From: Anita Gardner
Sent: 26 May 2017 14:42
To: Planning.Responses
Subject: FW: FW: Strategic Planning Response Re-consultation CM/7/17

I refer to our telephone conversation today and clarify that your concerns relate to the measures that will be required to accord with condition 4 which requires submission of details for approval and states.

At our meeting Council agreed to urgently raise concerns about the highways recommendations on lowering a wall and removing vegetation to allow for visibility splays re CM/7/17. This materially affects the planning application we originally made no objection to.

1703/SK2
1.12.16
RCA

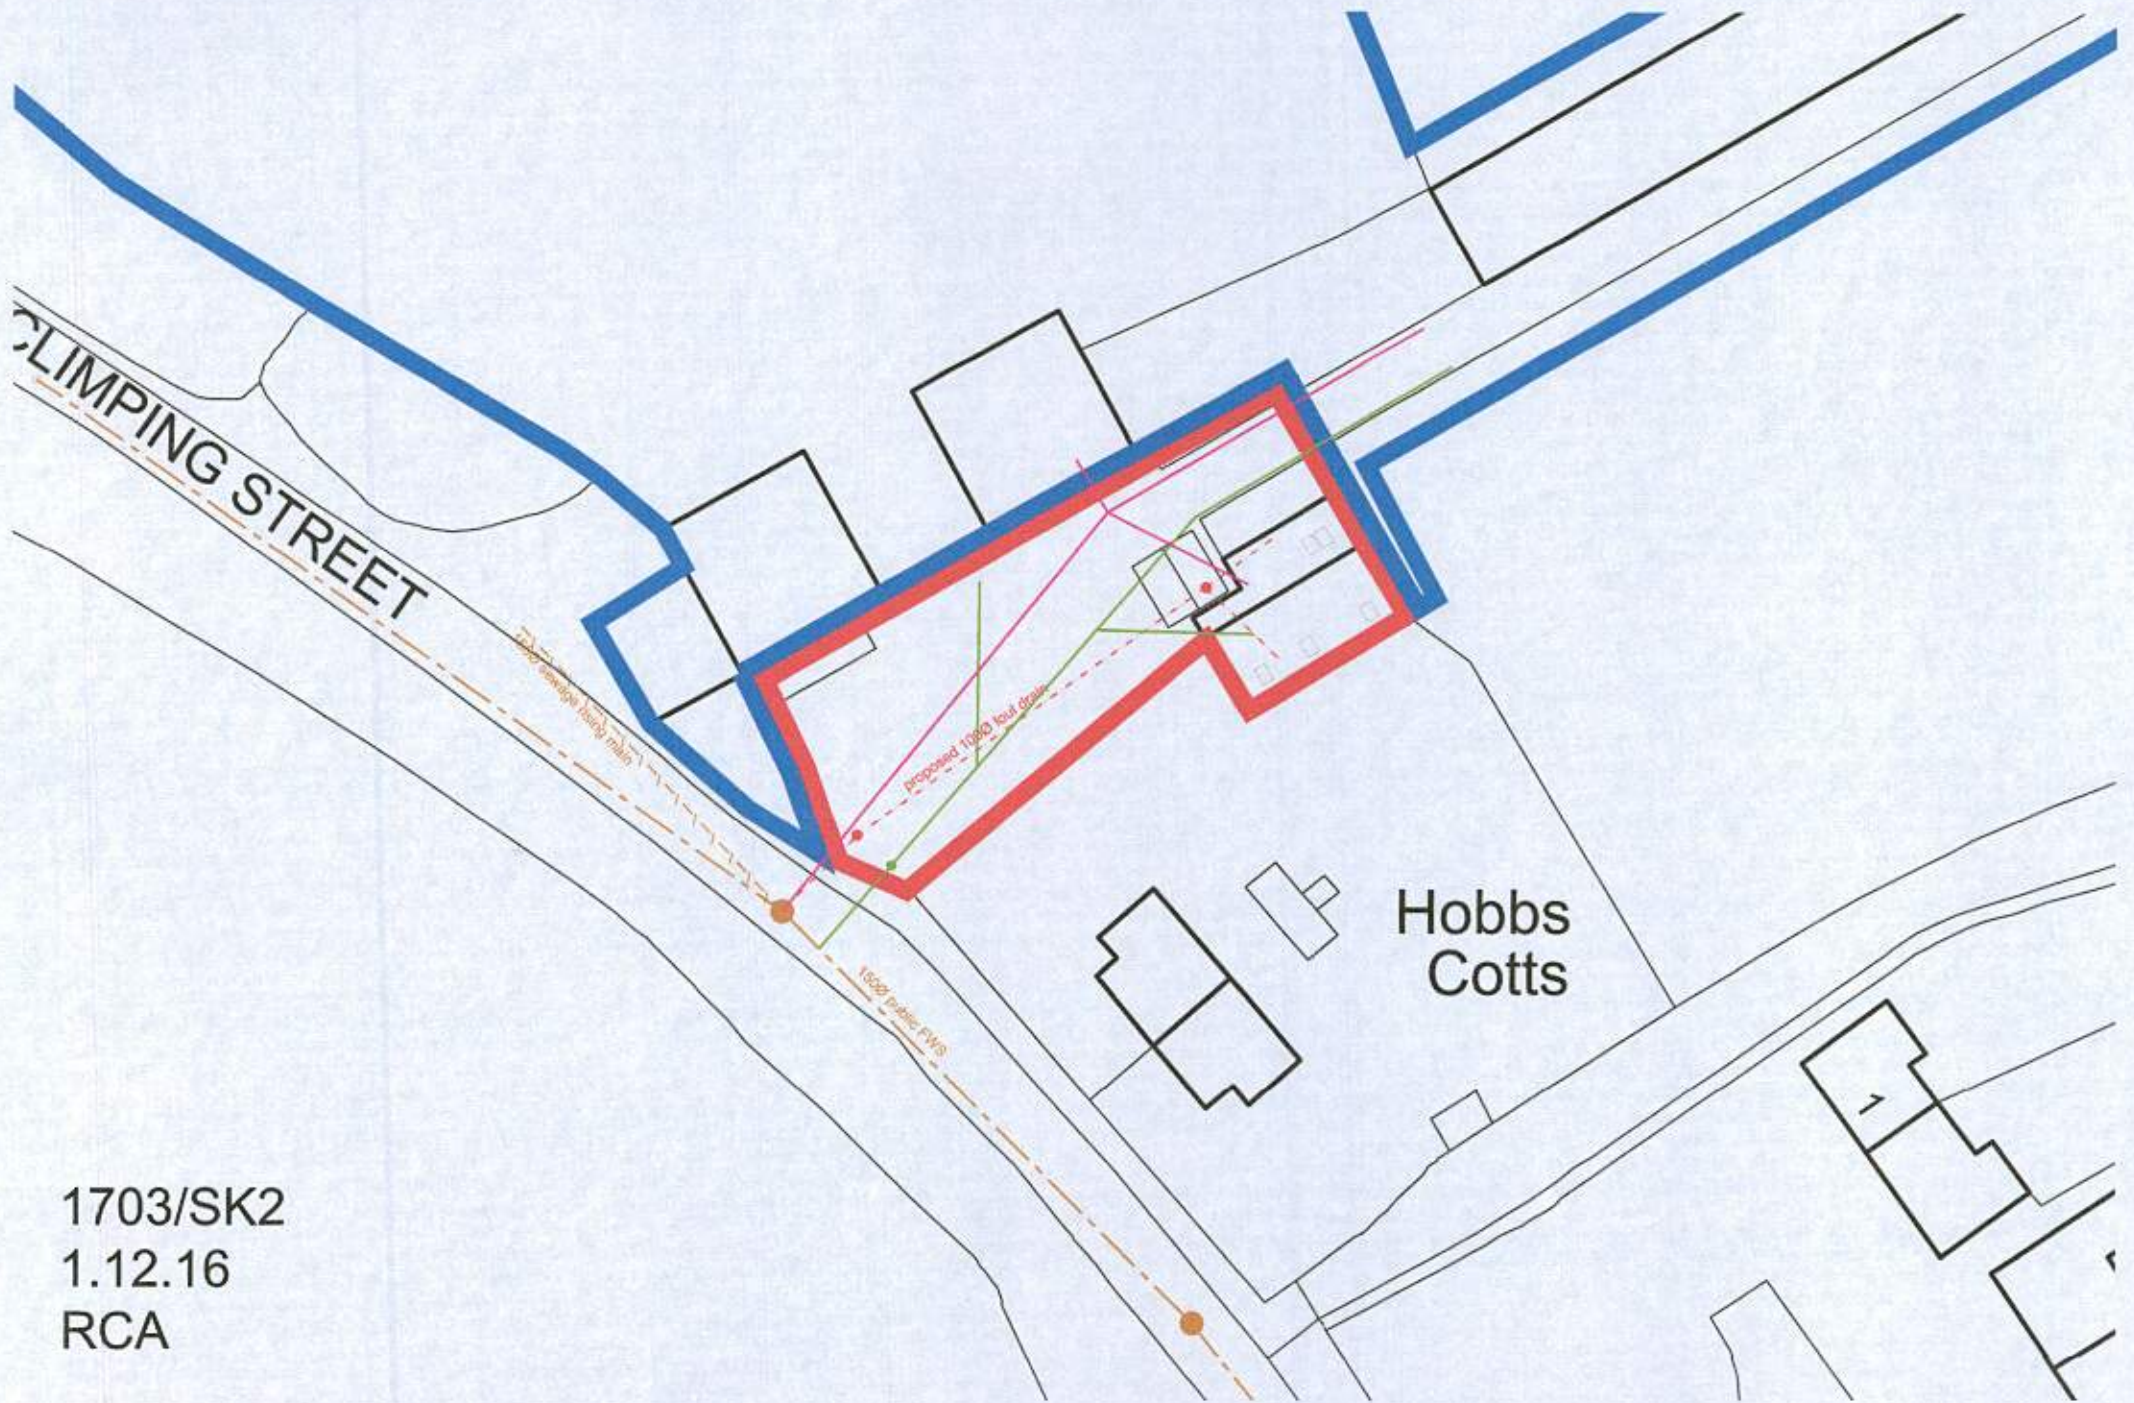
The proposal will seriously impact on the street scene in Clymping Street and on The Pound.

Council is particularly concerned that the flint walls should not be removed or damaged and that the well established tree which is set back from the road should be retained.

There is a newer concrete faced/brick wall to the southern boundary of The Pound which Council would have less objection to a slight lowering to match the height of the flint wall to the west boundary but we see no necessity for this to be required as other properties in Clymping Street have similar access arrangements.

Officers will investigate whether at that stage the impact on the street scene can be balanced against the visibility achievable when details are submitted in consultation with County.
